January 5, 2024

Re: Dunkin Drive-Through
3520 Menaul Boulevard NE
HT#H16D122

Kenig, Lindgren, O'Hara, Aboona, Inc. (KLOA, Inc.) has received the City of Albuquerque's comments in the January 3, 2024 letter regarding the above-referenced development. Below are our responses to the comments.

SITE PLAN

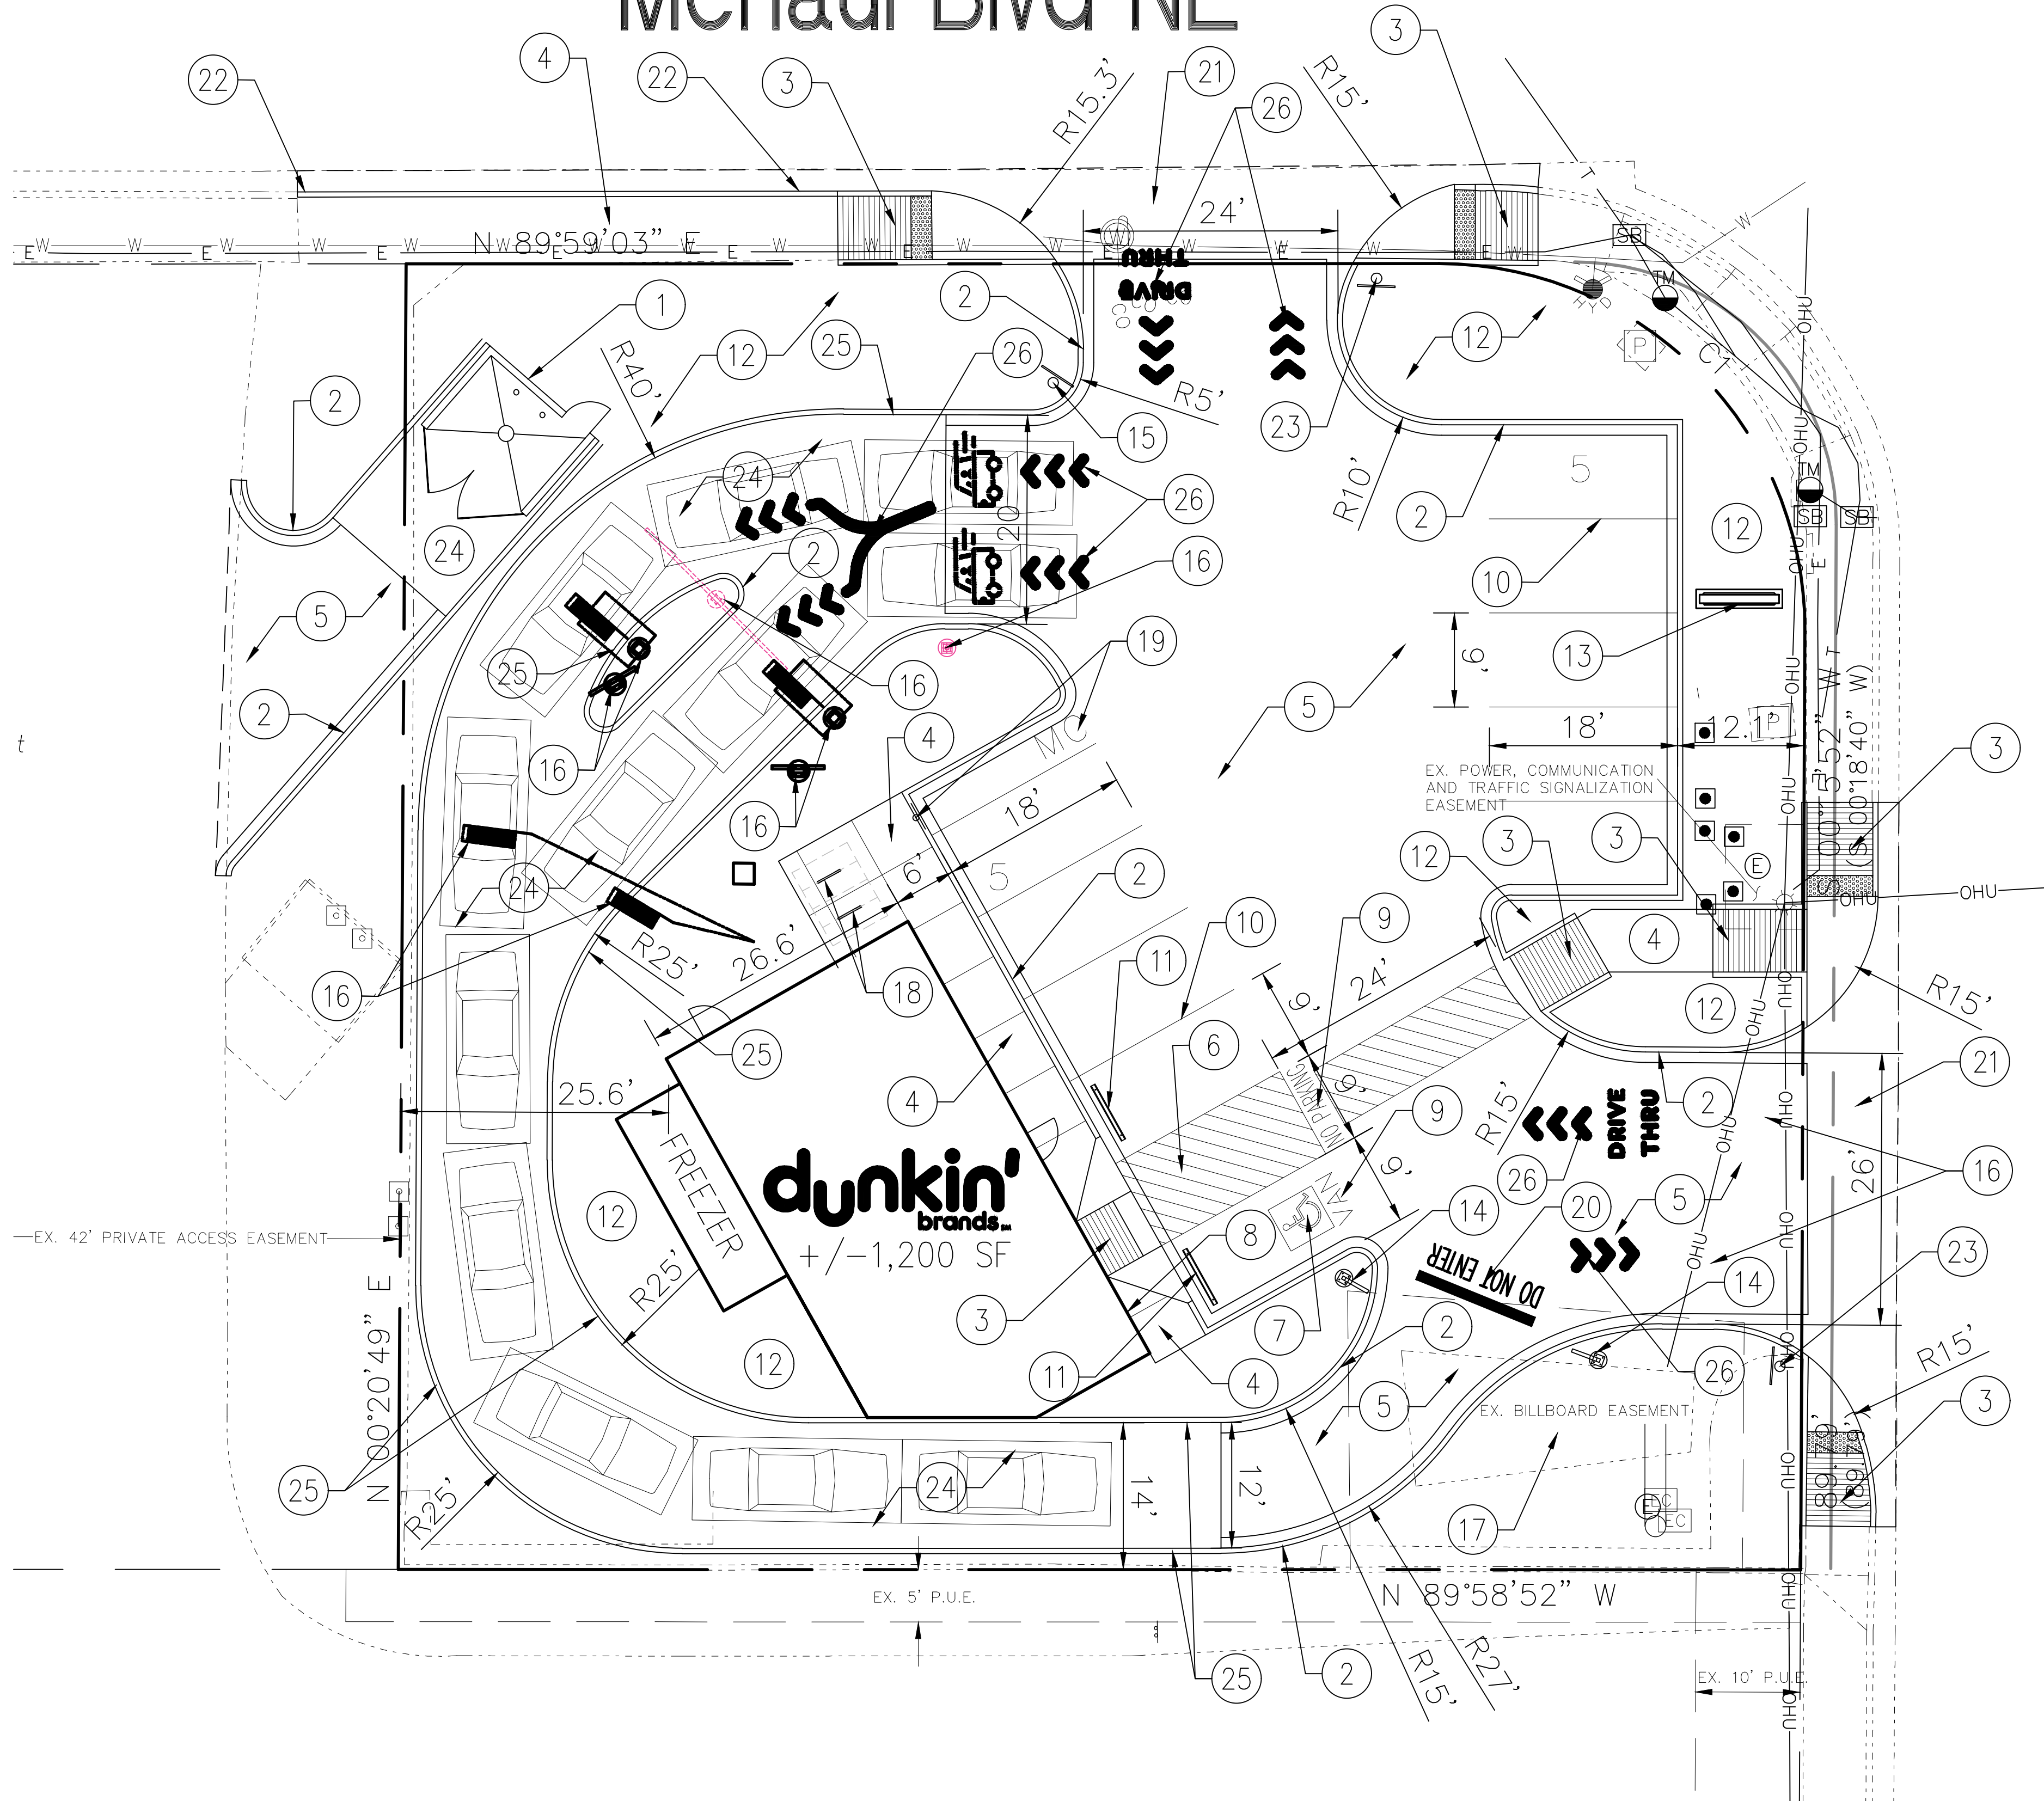
The proposed access on Menaul Blvd., an existing driveway, is too close to the approach of the intersection of Carlisle Blvd. When an access is located on a Principal Arterial approaching an Arterial the minimum distance for a commercial access from the intersection is a minimum 300 feet. Refer to CITY's DPM TABLE 7.4.45 Minimum Distance Between Commercial Site Access and Intersection. The driveway should be relocated to comply with the City's access location requirement. If the driveway is not relocated to be in compliance with the City's DPM an approved waiver, see TABLE 2.1.1 Summary of Development Procedures, is required before the TIS can be finalized for approval by the City.

Response: The location of the proposed access drive has been approved as confirmed by Ernest Armijo in correspondence dated December 12, 2023. This correspondence has been included in the appendix of the revised traffic impact study.
